Our ref: AN/2024/135611/03-  
L01

Date: 09 December 2024

## **Order Granting Development Consent for the Tillbridge Solar Project (EN010142) - Examining Authority's first written questions.**

**Volume 6
Environmental Statement
Figure 3-12: Typical Trenchless Crossing Cross Sections
Document Reference: EN010142/APP/6.3**

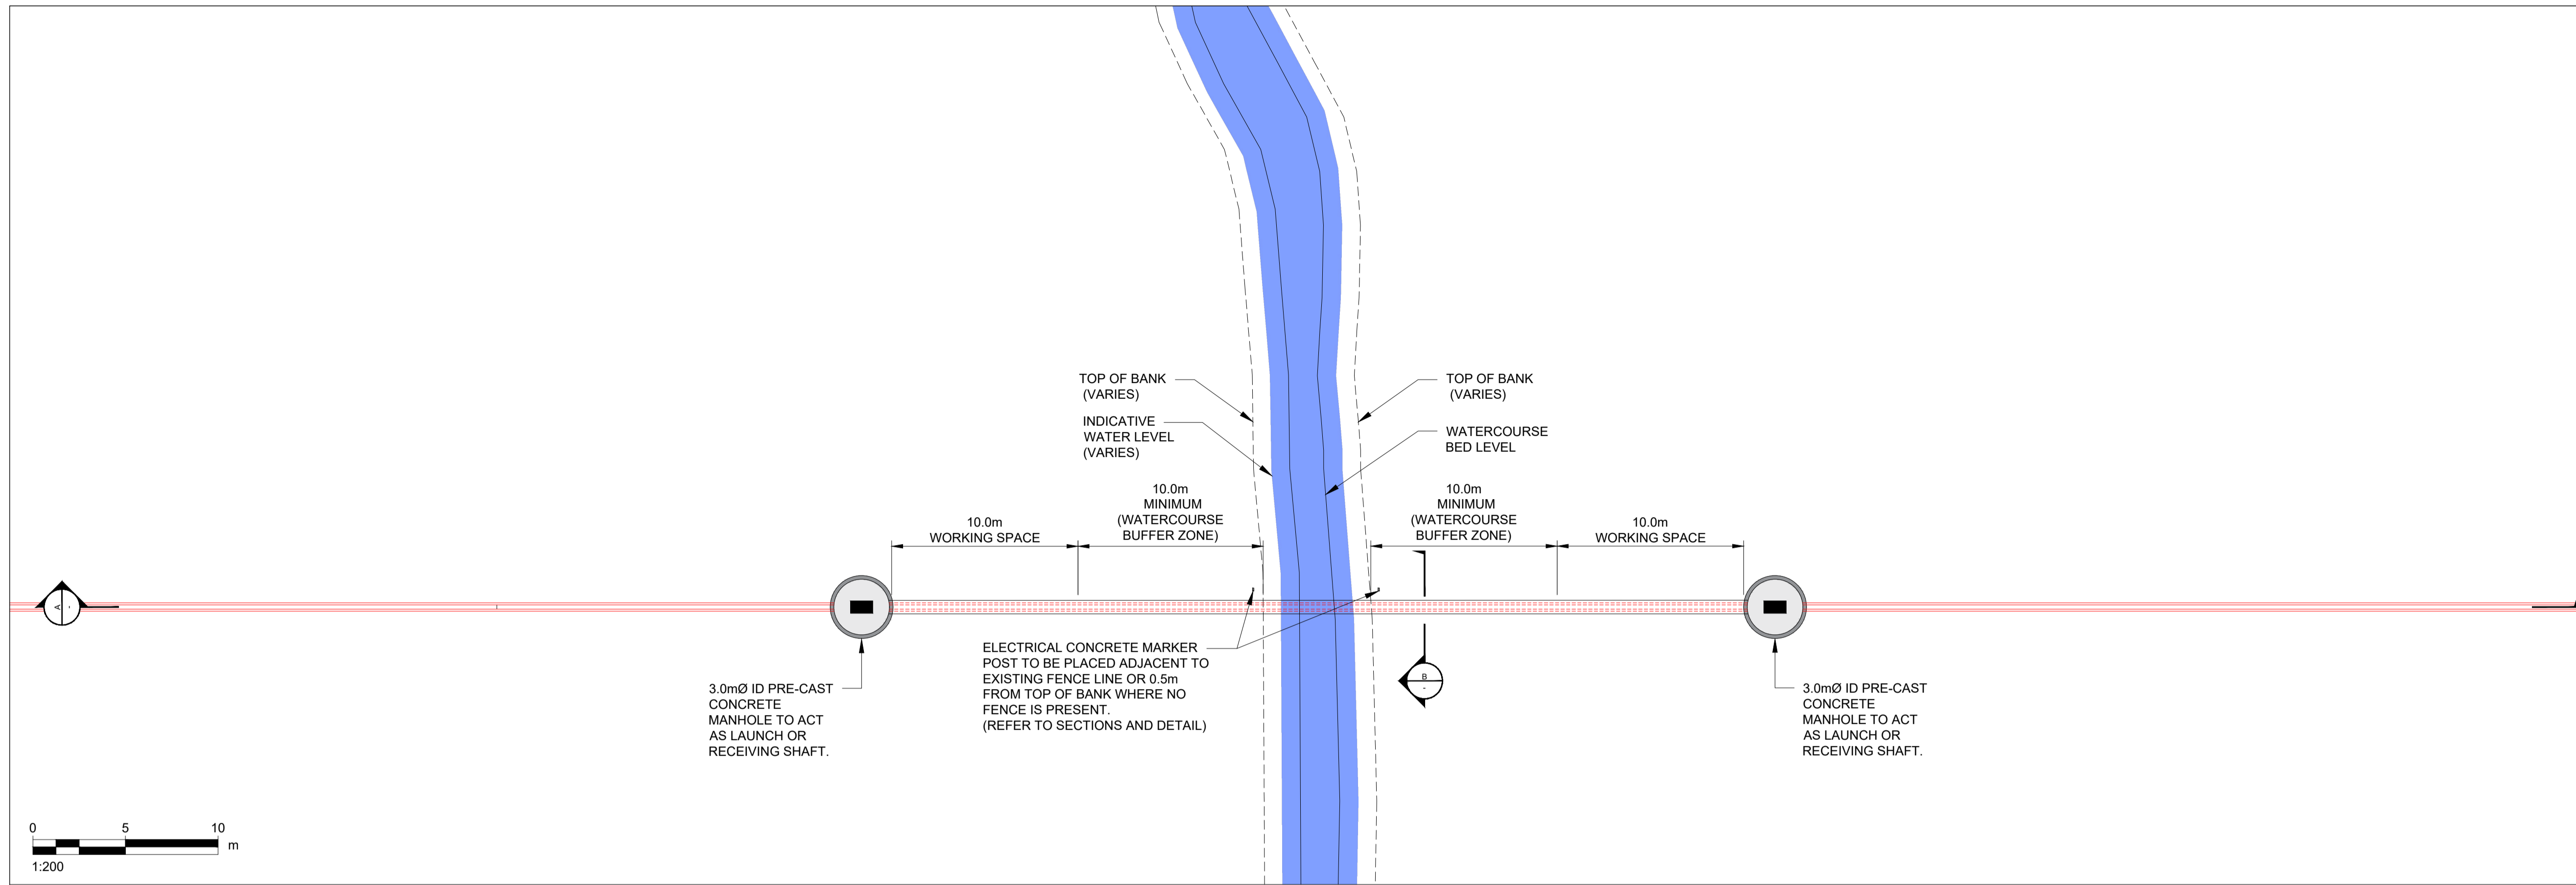
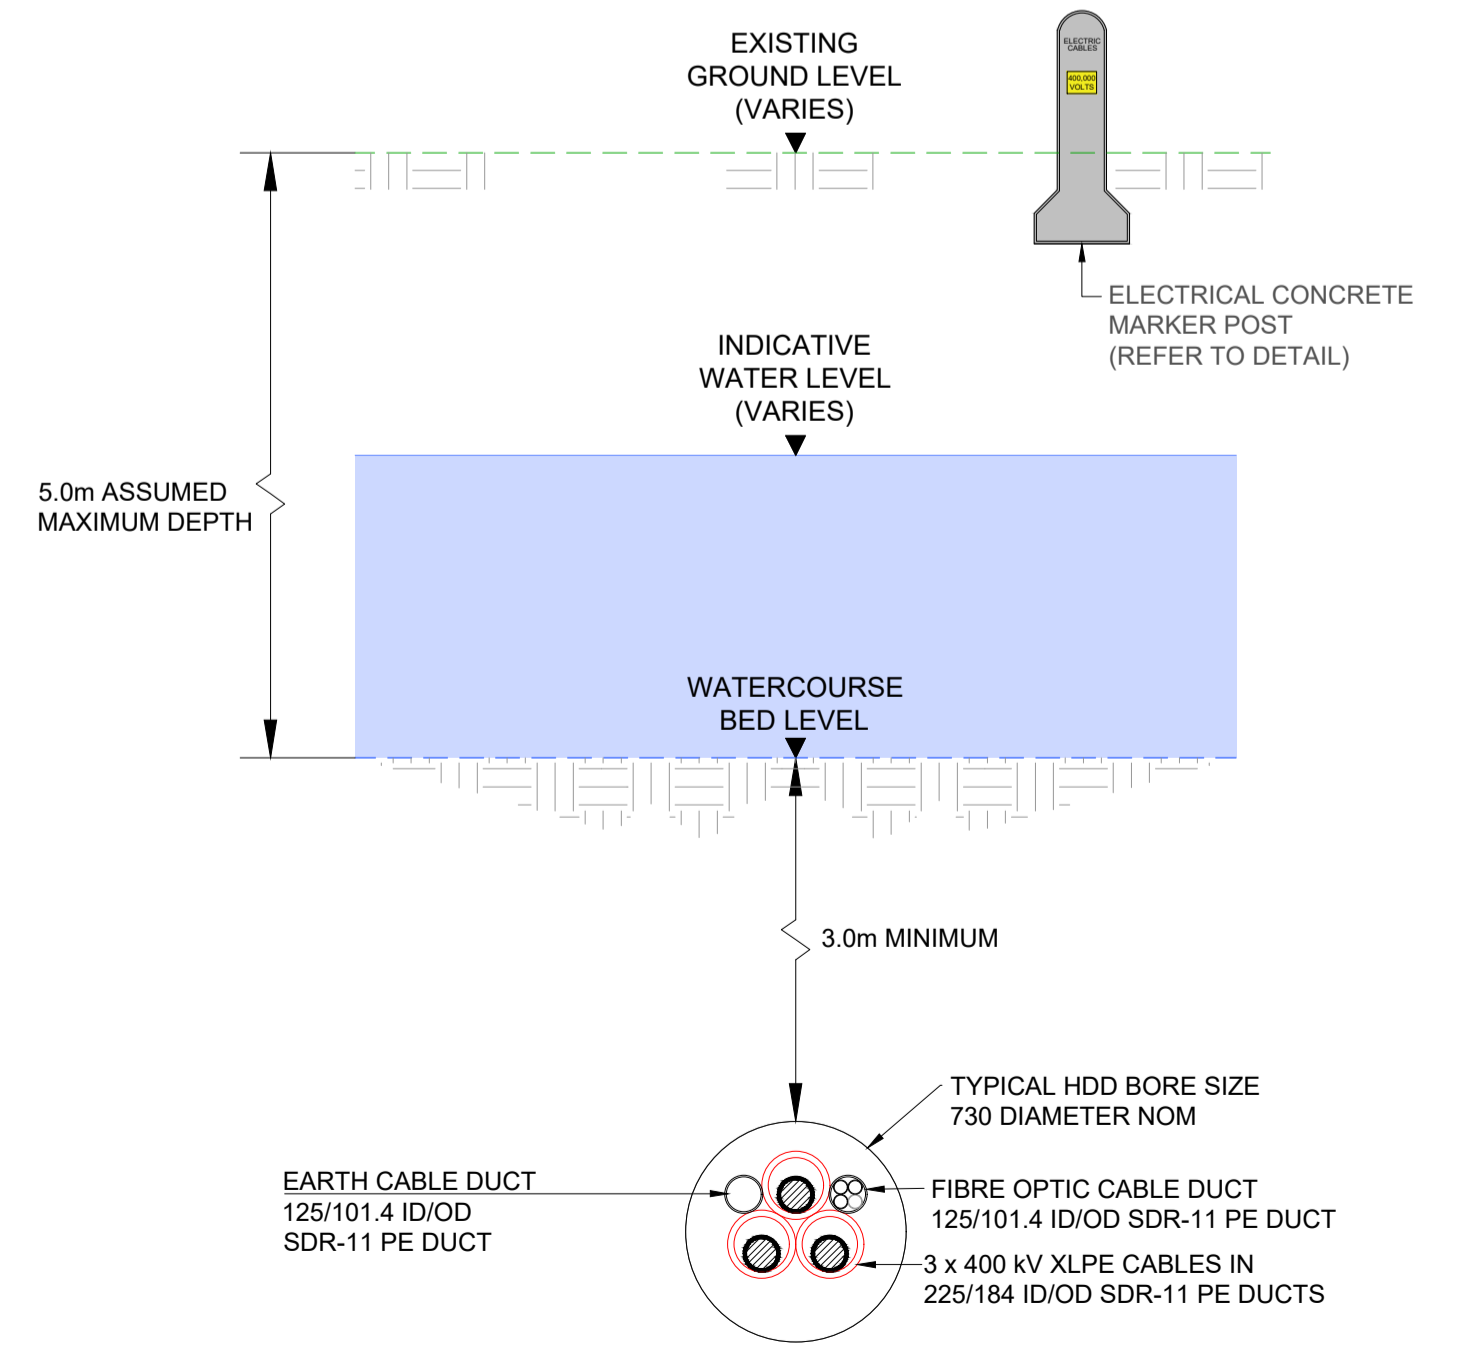
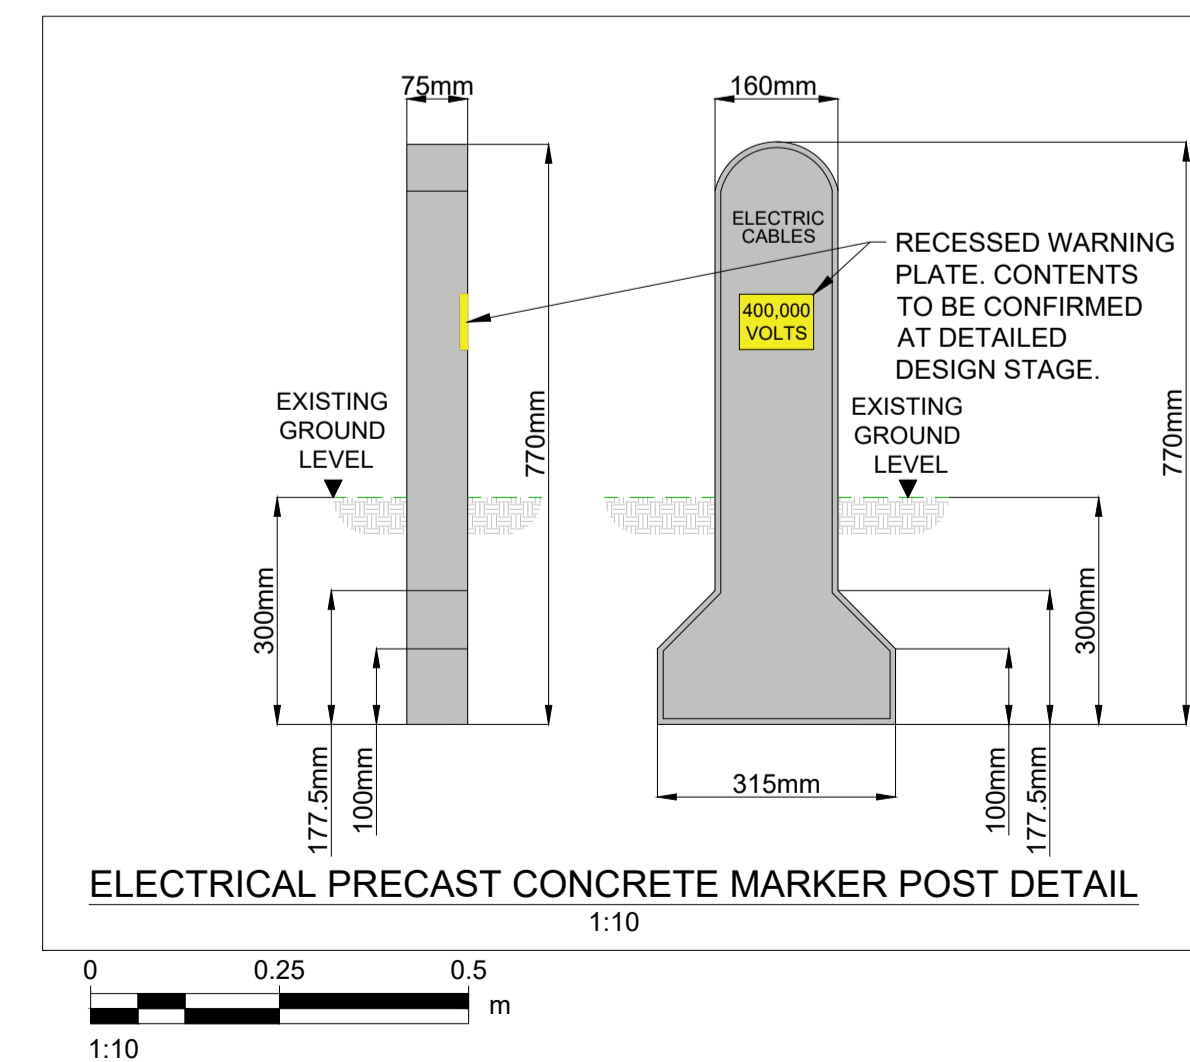
We assume the 'working pit locations' you refer to are the chambers that are shown either side of the river on Figure 3-12 Typical Trenchless Crossings Cross Sections (EN010142-000323-6.3) which are to be covered by manholes for future access and that HDD stands for Horizontal Directional Drilling.

On this basis, we are not aware of channel erosion being a major issue in this area of the River Trent. There are flood defences either side of the Trent in this location which have been in place for over 50 years. We do not therefore expect erosion to affect the proposed manholes. However, the applicant's plans will involve the cable route passing through the Environment Agency (EA) flood defences which are not shown on their indicative plans. The applicant has said that they will re-consult us with their detailed plans which we will need to assess and comment on to ensure that the proposals do not adversely affect the EA defences.
